**DEVIATION REVIEW
 AND DECISION FORM**

Deviation No. 3
REV. 4-19-2019

Subdivision or Project Name: Rollin' Ridge Estates

Section of ECM from Which Deviation is Sought: 2.3.7.E Intersections - Turn Lane Design

ENTRY DETAIL

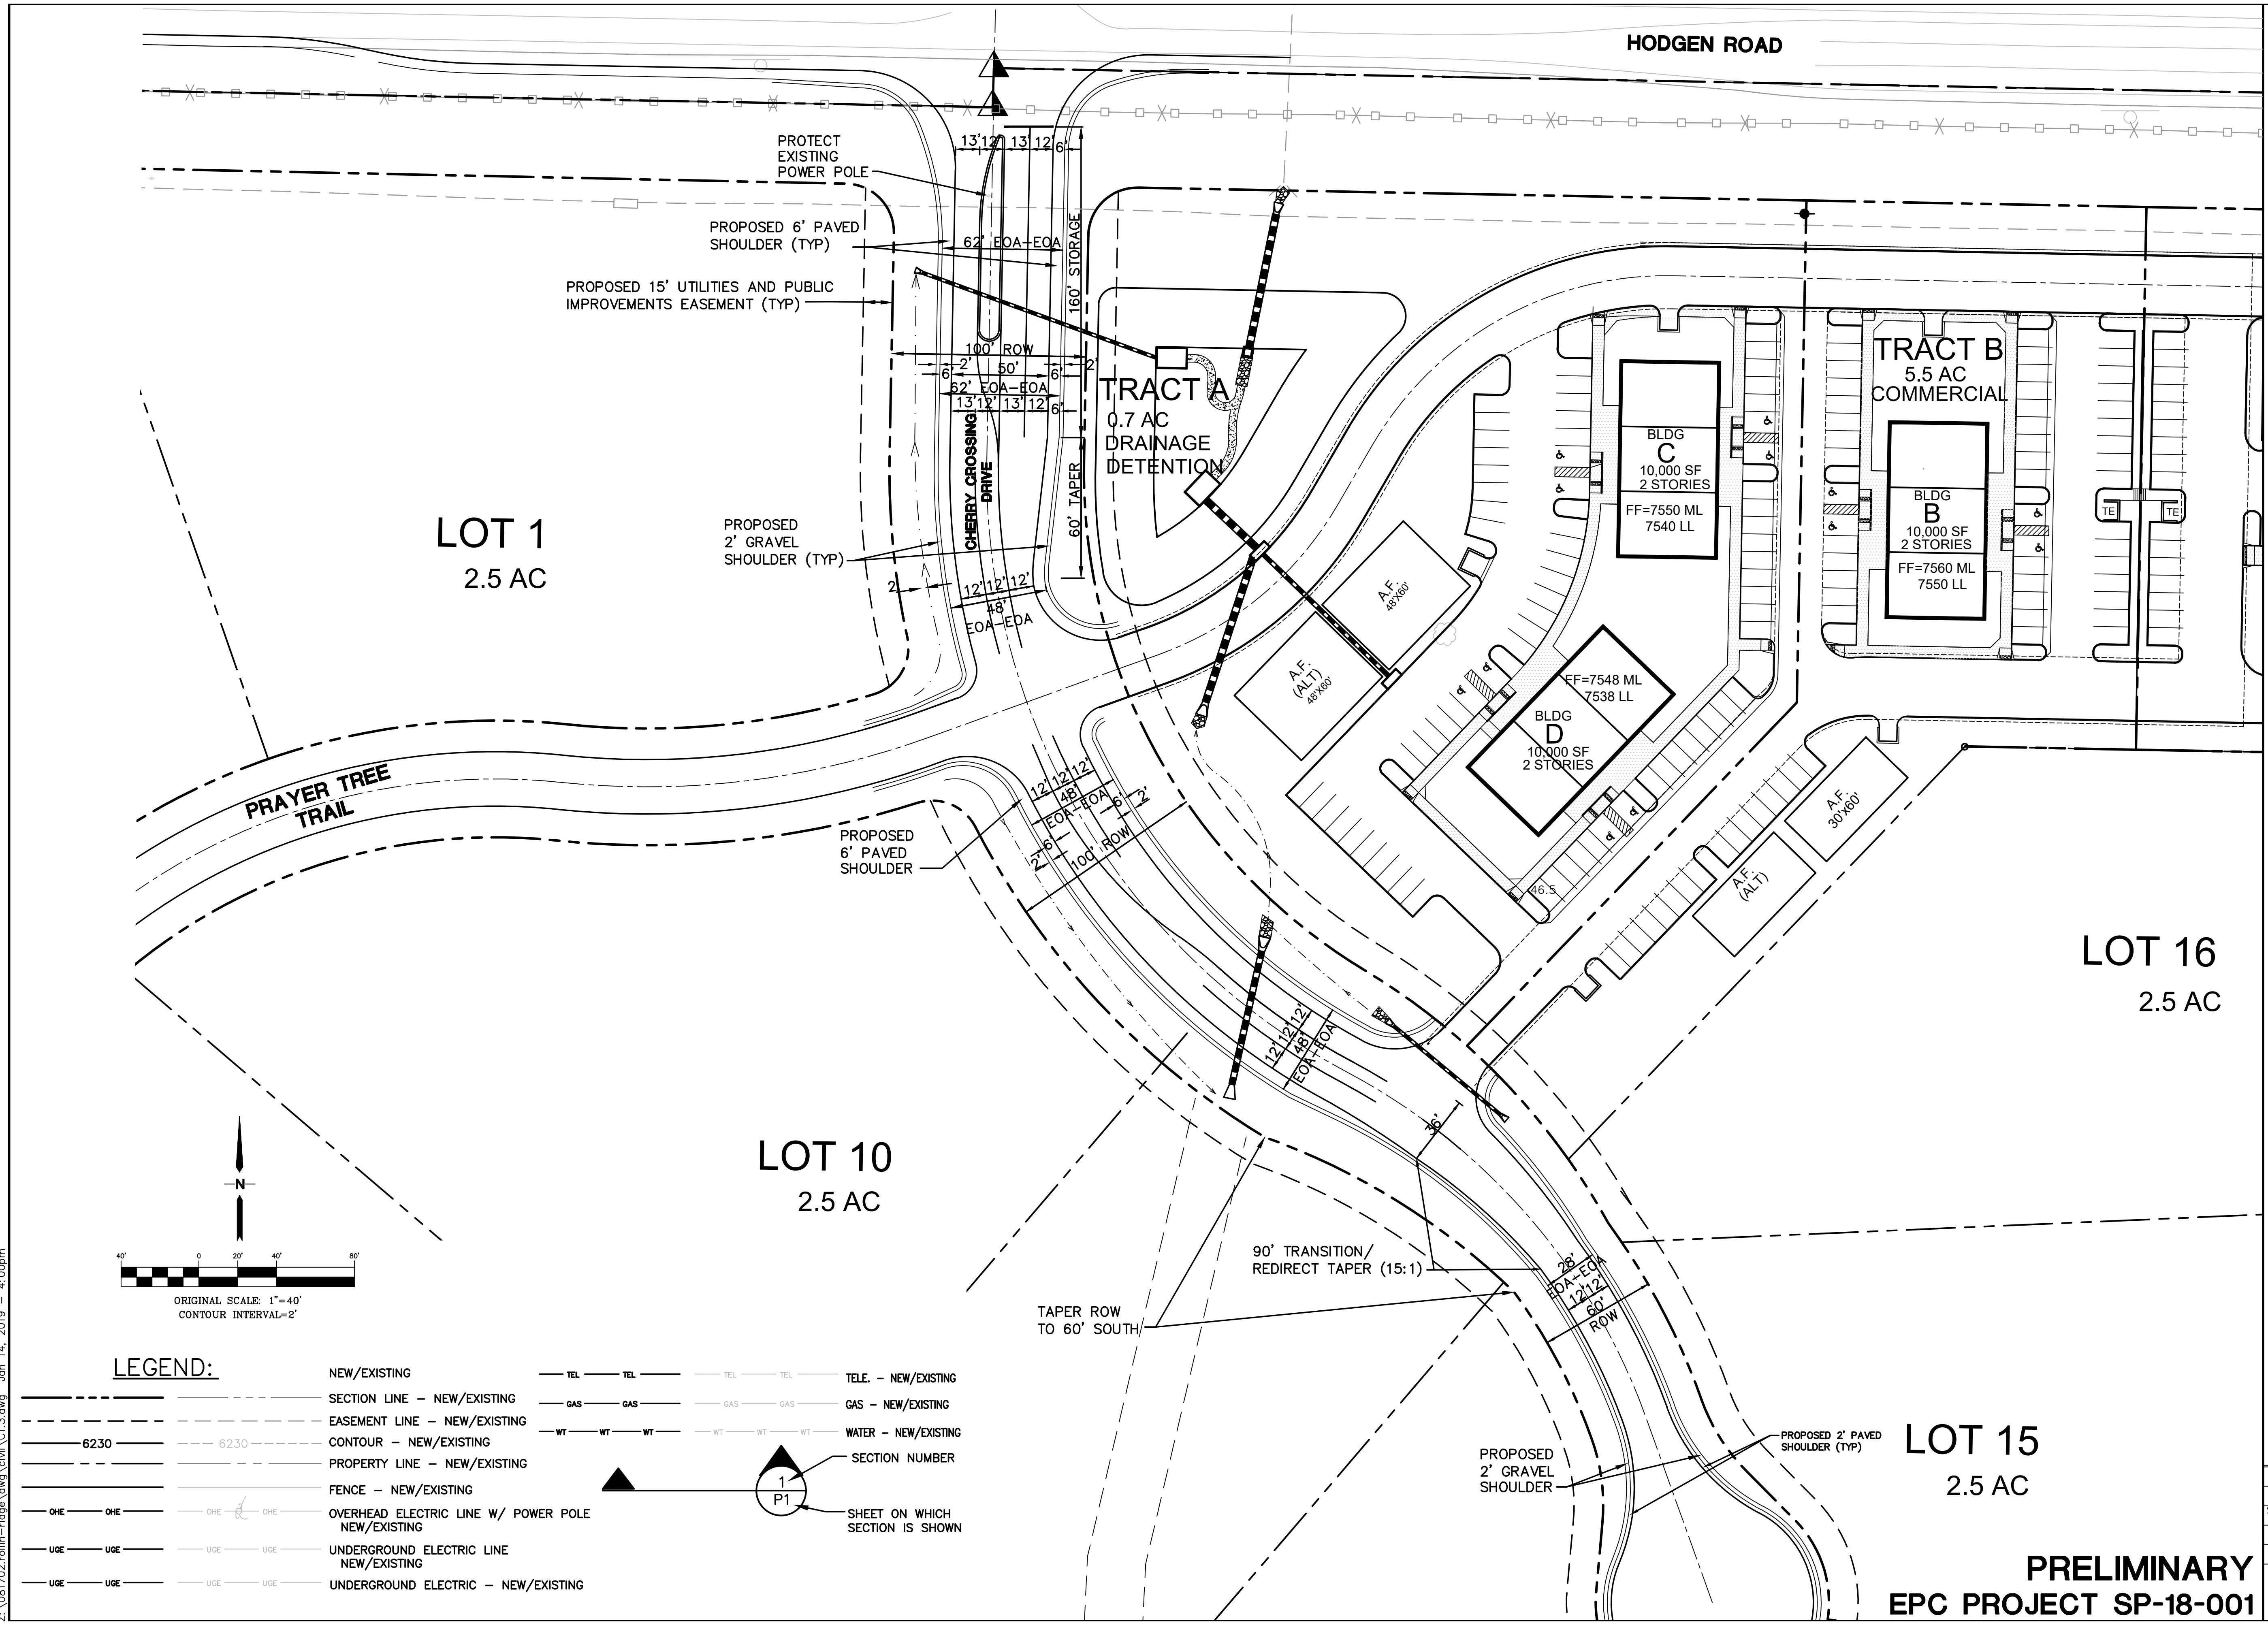
Proposed Nature and Extent of Deviation: Allow an abbreviated northbound right turn lane at the intersection of Cherry Crossing Drive & Hodgen Road. The lane would extend from the intersection of Hodgen Road south to the proposed intersection of Cherry Crossing Drive/Prayer Tree Trail/north commercial access and would be a continuous northbound right turn lane between these intersections. The lane length would be about 250 feet.

Proposed Nature and Extent of Deviation: Allow an abbreviated northbound right turn lane at the intersection of Cherry Crossing Drive & Hodgen Road. The lane would extend from the intersection of Hodgen Road south to the proposed intersection of Cherry Crossing Drive/Prayer Tree Trail/north commercial access and would be a continuous northbound right turn lane between these intersections. The lane length would be about 250 feet. Please refer to Entry Detail exhibit (attached).

Reason for the Requested Deviation: The proposed centerline spacing along Cherry Crossing Drive between Hodgen Road and the north commercial access is 360 feet (see separate deviation request for this proposed spacing). An ECM-standard northbound right-turn deceleration lane and taper would not fit between these proposed two intersections based on the standard design speed of an ECM-standard Rural Minor Arterial. Note: This proposed lane length would meet criteria for a 30-mph design speed (235 feet required), which per Deviation No. 1 is the anticipated speed for Cherry Crossing Drive.

The proposed 250-foot-long northbound right-turn lane will provide about 100 feet more than the ECM-Standard stacking distance of 150 feet. Although this street is proposed to be classified as a Rural Minor Arterial, this classification is primarily based on the ADT rather than the length and continuity of the roadway. Given the limited land use proposed to be served by the street and the short length of the street, the vehicle speeds will be significantly lower than 60 mph ECM-standard design speed of a Rural Minor Arterial. This proposed lane length would meet criteria for a 30-mph design speed (235 feet required), which per Deviation No. 1 is the anticipated speed for Cherry Crossing Drive.

Also, this street will function as an "entry drive" rather than a major through-roadway. For these reasons, the proposed laneage will be functional and appropriately designed for this site-specific condition. Please refer to the proposed laneage shown in the Entry Detail exhibit (attached).

The proposed 250-foot-long northbound right-turn lane will provide about 100 feet more than the required stacking distance of 150 feet. The queuing analysis included in the Rollin Ridge Traffic Impact Study (TIS) indicates that the projected queues can be accommodated by the proposed laneage shown in the Entry Detail exhibit (attached). Please refer to the queuing section in the TIS.

This request has been determined to have met the criteria for approval. A deviation from Section 2.3.7 of ECM is hereby granted based on the justification provided. Comments:
